DECISION DELEGATED TO HEAD OF PLANNING

Application No: H02-0747-23 **Applicant:** Mr G Jenkins

Proposal: Change of use of dwelling to include the use for dog breeding - re-submission of H02-0030-23 - retrospective

Location: 67 North Street Crowland Spalding

PLAN A

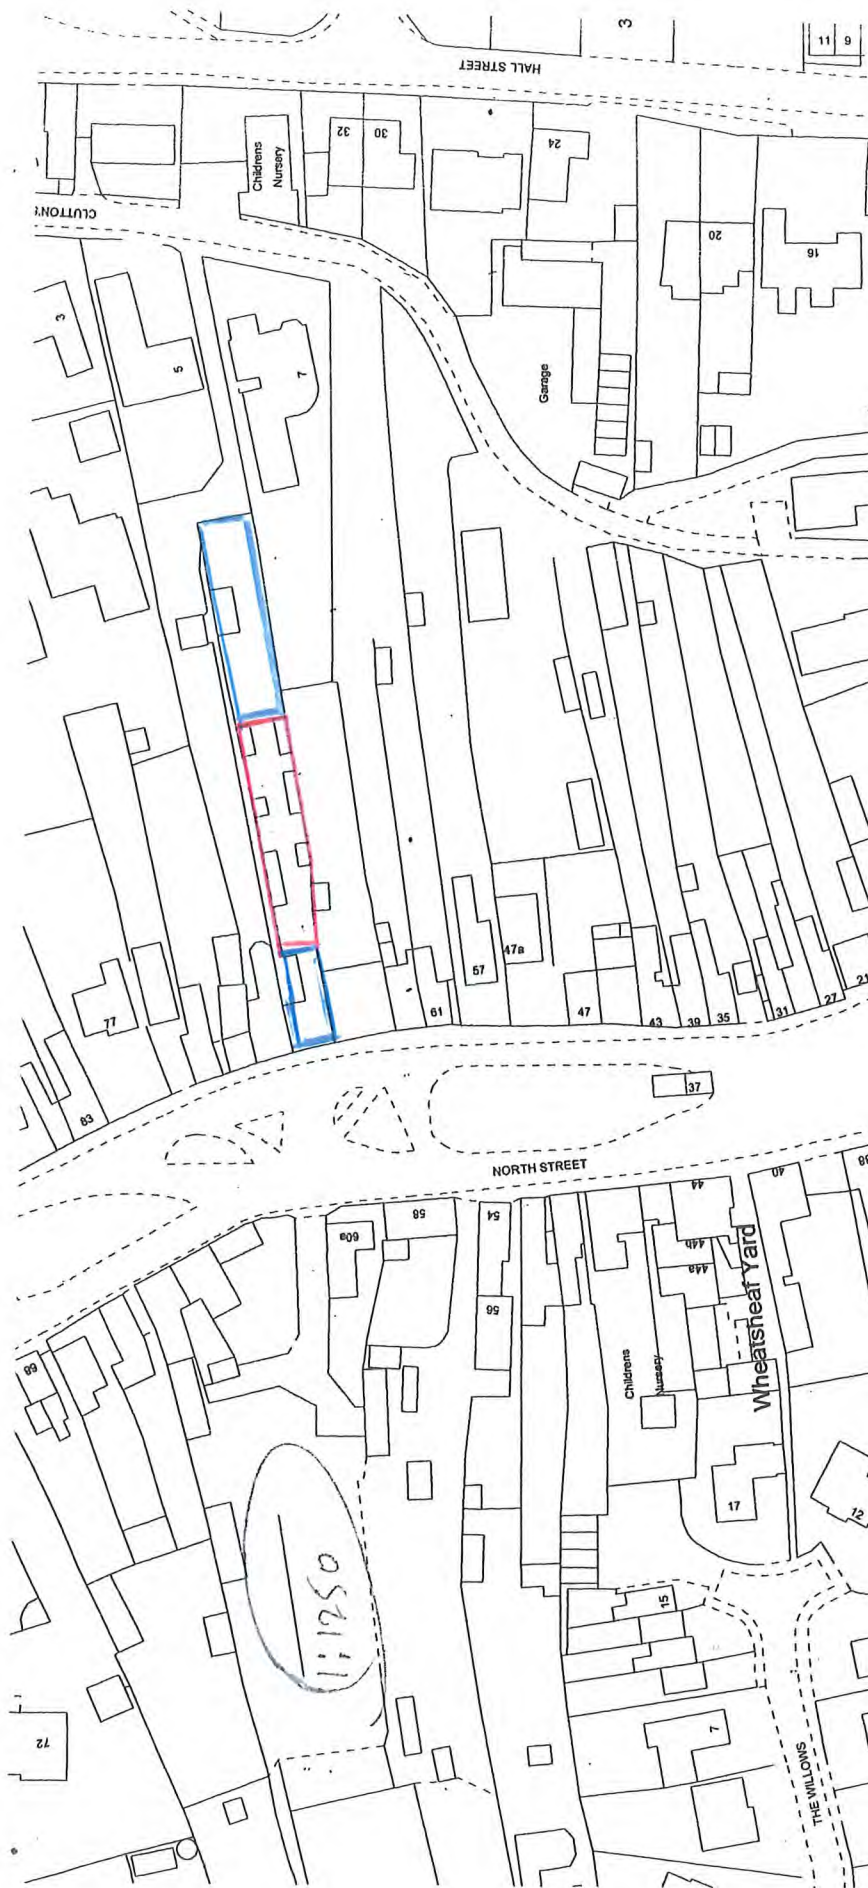
The application site is a mid-terrace property with a long garden, within a residential area of Crowland. The kennels to the south are right on the shared boundary of the Old Crown Cottage 65 North Street, with the kennels on the north being around 1.29m from the boundary of No.69 North Street. There are also neighbouring dwellings to the rear of the site, with the separation distances varying between 4m and 37m from the kennels. At such separation distances, the number of dogs is sufficiently high to create disturbance to the residents of the nearest dwellings.

It has been noted that the submitted block plan and site location plan is not accurate. Within the submitted covering letter the applicant has stated that "have rehomed 10 of our dogs and currently have 16. 5 of which live in doors" As some of the dogs are living inside the dwelling house and not outside within the kennels the dwelling house also needed to be included within the red outline of the site location and block plan. The covering letter also confirms that "our puppies are raised in a downstairs puppy room within the house," highlighting further that the dwelling house is used for the dog breeding business.
